Re: Interior Alteration Commercial
6805 Academy Parway West
Traffic Circulation Layout
Engineer's/Architect's Stamp 08-01-2019 (E17D073)

Based upon the information provided in your submittal received 08-02-2019, the above referenced plan cannot be approved for Building Permit until the following comments are addressed:

TCL

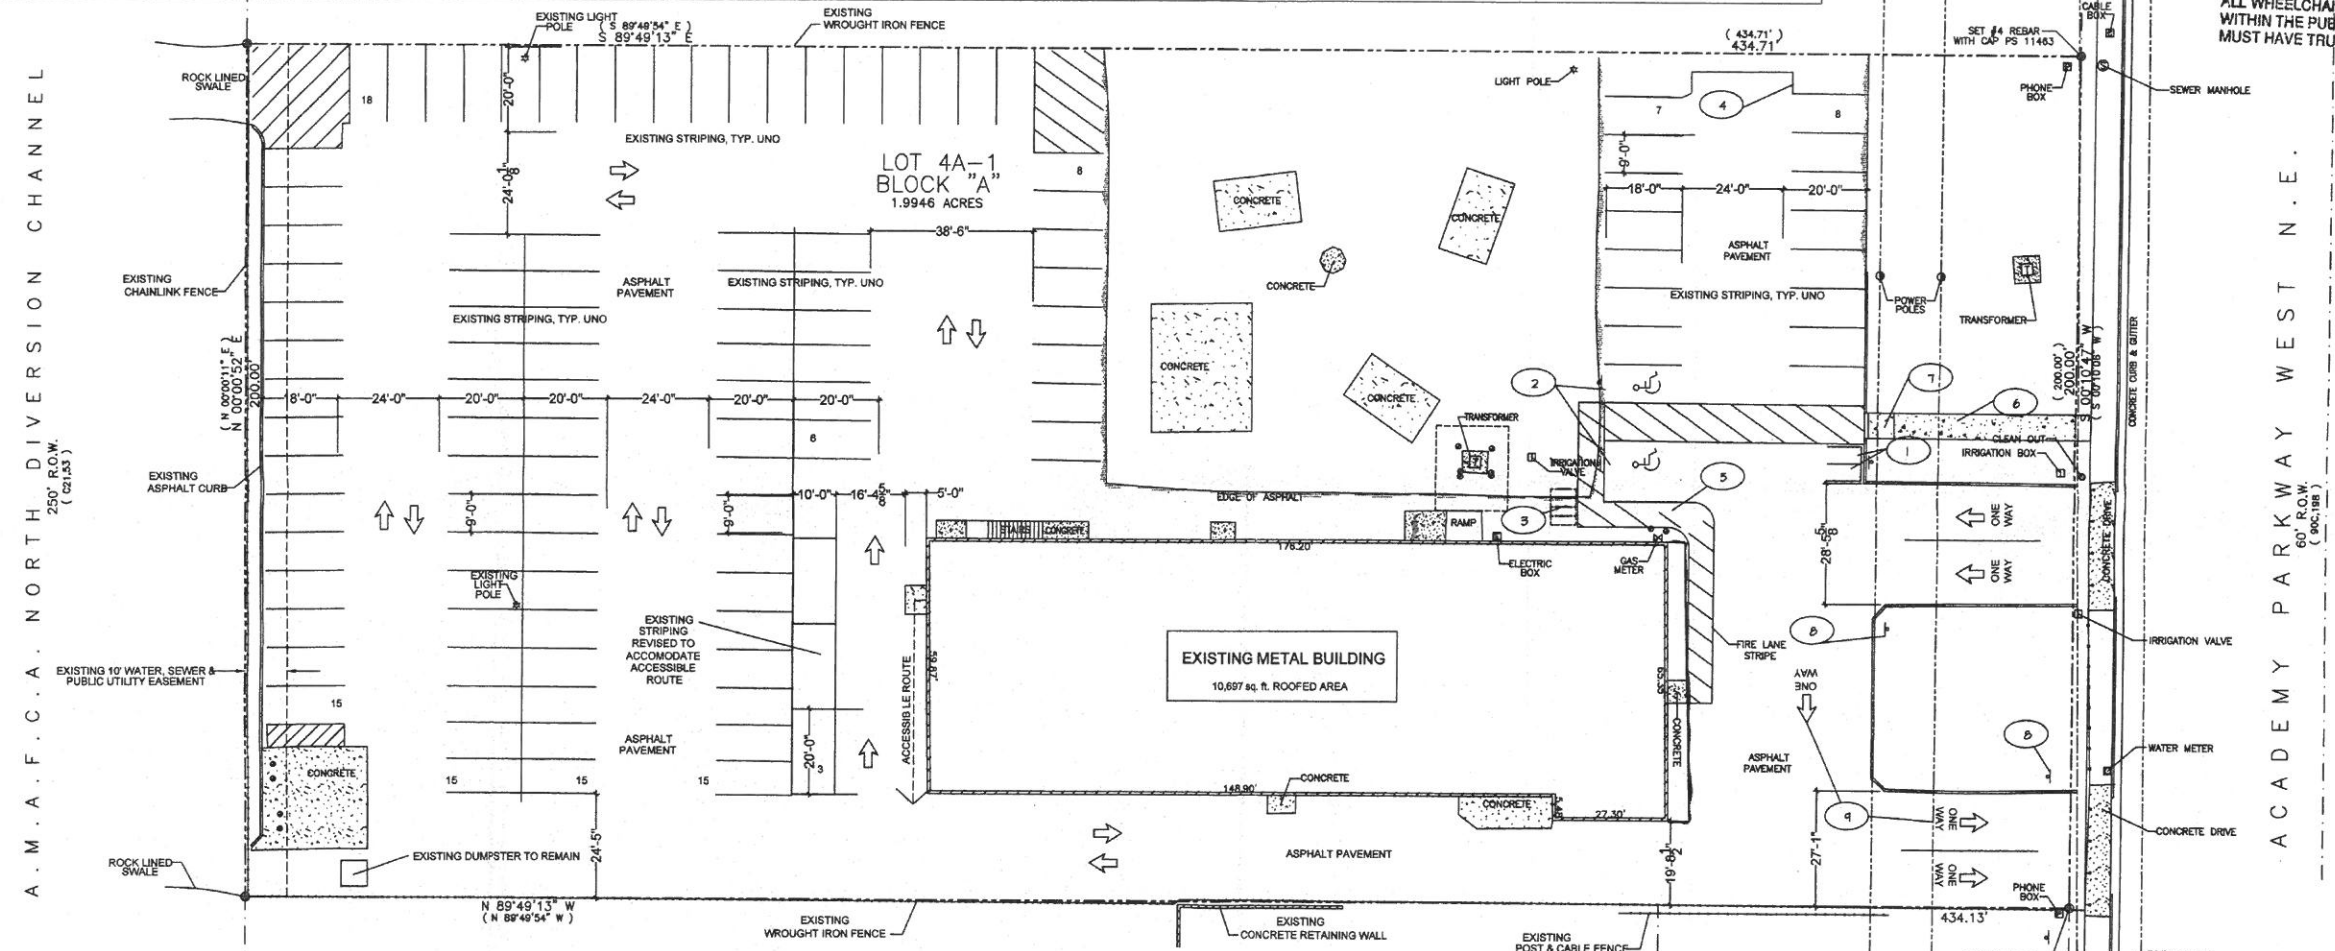
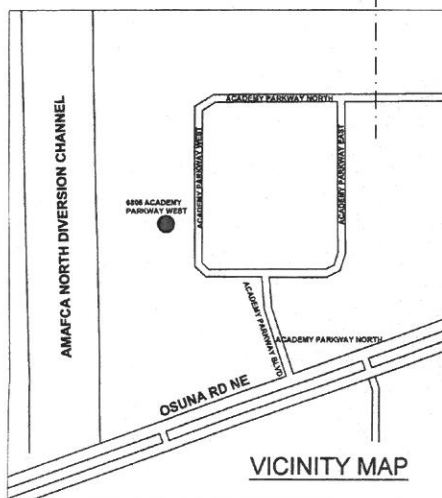
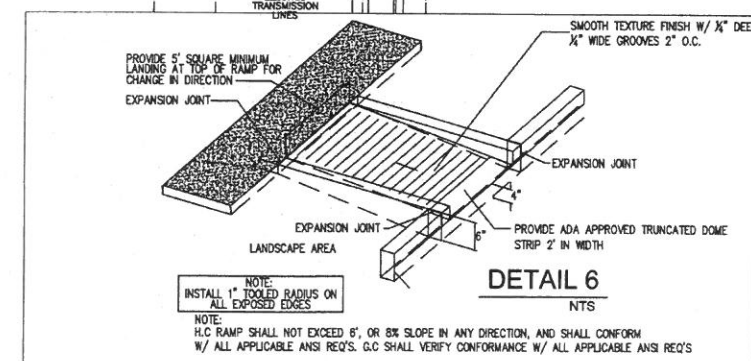
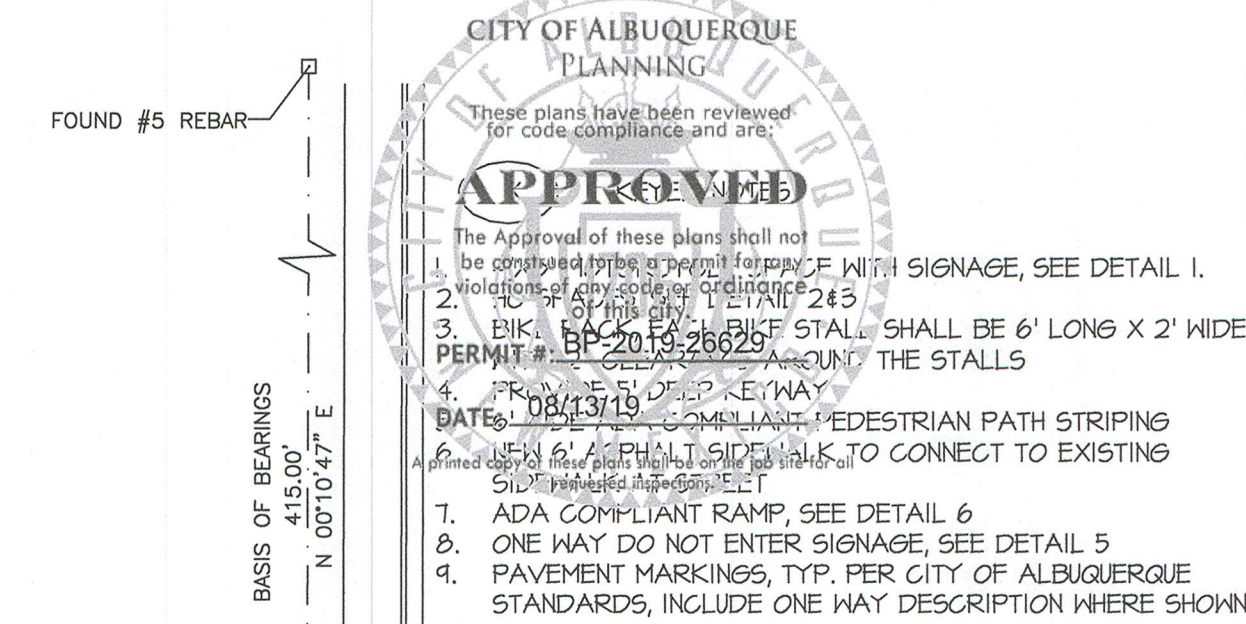
1. List the number of parking spaces required by the zoning code as well as the proposed number of parking spaces **including bicycle and motorcycle parking.**

2. Please show the the ADA access space. The dimension is not shown.
3. The ADA sign is not shown: The ADA accessible parking sign must have the required language per 66-7-352.4C NMSA 1978 **"Violators Are Subject to a Fine and/or Towing."** Please call out detail and location of signs.

4. The ADA access aisles shall have the words **"NO PARKING"** in capital letters, each of which shall be at least one foot high and at least two inches wide, placed at the rear of the parking space so as to be close to where an adjacent vehicle's rear tire would be placed. (66-1-4.1.B NMSA 1978)

5. Motorcycle parking spaces shall be designated by its own conspicuously posted upright sign, either free-standing or wall mounted per the zoning code.

6. All bicycle racks shall be designed according to the following guidelines:
 - a. The rack shall be a minimum 30 inches tall and 18 inches wide.
 - b. The bicycle frame shall be supported horizontally at two or more places. Comb/toaster racks are not allowed.

- c. The rack shall be designed to support the bicycle in an upright position. See the IDO for additional information.
 - d. The rack allows varying bicycle frame sizes and styles to be attached.

- e. The user is not required to lift the bicycle onto the bicycle rack.
 - f. Each bicycle parking space is accessible without moving another bicycle.

7. Bicycle racks shall be sturdy and anchored to a concrete pad.
8. A 1-foot clear zone around the bicycle parking stall shall be provided.
9. Bicycle parking spaces shall be at least 6 feet long and 2 feet wide.

10. A 5 ft. keyway is required for dead-end parking aisles.
11. Per the IDO, a 6 ft. wide ADA accessible pedestrian pathway is required from the public sidewalk to the building entrances. Please clearly show this pathway and provide details.

12. Per DPM, a 6 ft. wide ADA accessible pedestrian pathway is required from the ADA parking stall access aisles to the building entrances. Please clearly show this pathway and provide details.

13. ADA accessible pedestrian pathway should not be placed behind parking space or adjacent to a vehicular way. Vehicle and pedestrian/wheel chair conflicts should be avoided as much as possible.

14. Refuse vehicle maneuvering shall be contained on-site. The refuse vehicle shall not back into the public right of way.; provide a copy of refuse approval.

15. All one-way drives shall have "One Way" and "Do Not Enter" signage and pavement markings. Please show detail and location of posted signs and striping.
